The Coal
Authority

Re: Planning application 2025/60/91219/E

Outline application for erection of residential development (one dwelling) at Land off Coal Pit Lane, Lower Cumberworth, Huddersfield, HD8 8PL

Figure 14 Mine Entry Potential Zone of Influence

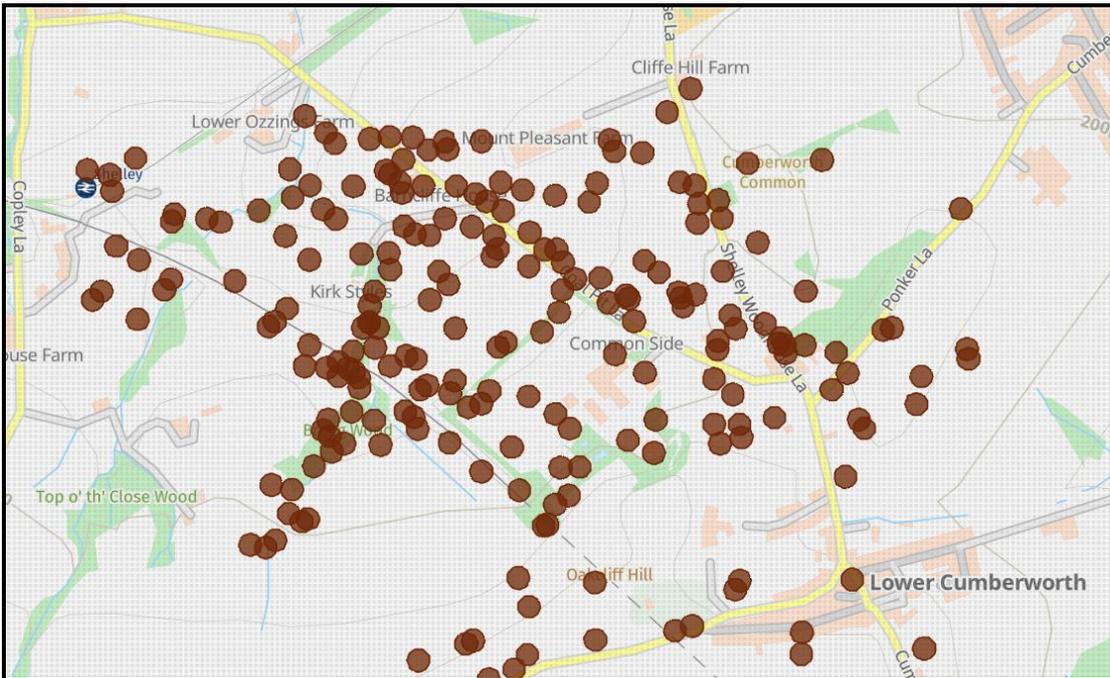
Our records indicate that there are three off-site mine entries present within 20m of the site boundary (shafts 421409-051 and 421409-052 and adit 421409-024), with their associated potential zones of influence extending towards the site. Due to potential plotting inaccuracies, the actual positions of these mine entries could depart/deviate from their plotted positions by several metres. We hold no details of any past treatment of these former coal mining features. An untreated or inadequately treated mine entry and its resultant zone of influence pose a significant risk not only to surface stability but also public safety.

With regards to the recorded mine entries, our information would suggest that it is unlikely that the potential zones of influence of these features would extend in the application site, taking into consideration their plotted positions, departure distances and anticipated ground conditions. Nevertheless, the report recommends the undertaking of trial pits along the site boundary to establish whether the mine entries are present on site, the need for any treatment of these features and to inform the layout of the development.

- 2. Any reserved matters application seeking approval of a detailed layout of development, shall be accompanied by: the findings of the intrusive site investigations (required by condition X above), and a proposed layout plan which identifies the alignment of any buried opencast highwall present within the site and the extent of any mine entry zones of influence, along with the definition of any necessary 'no build' zones over these features.***
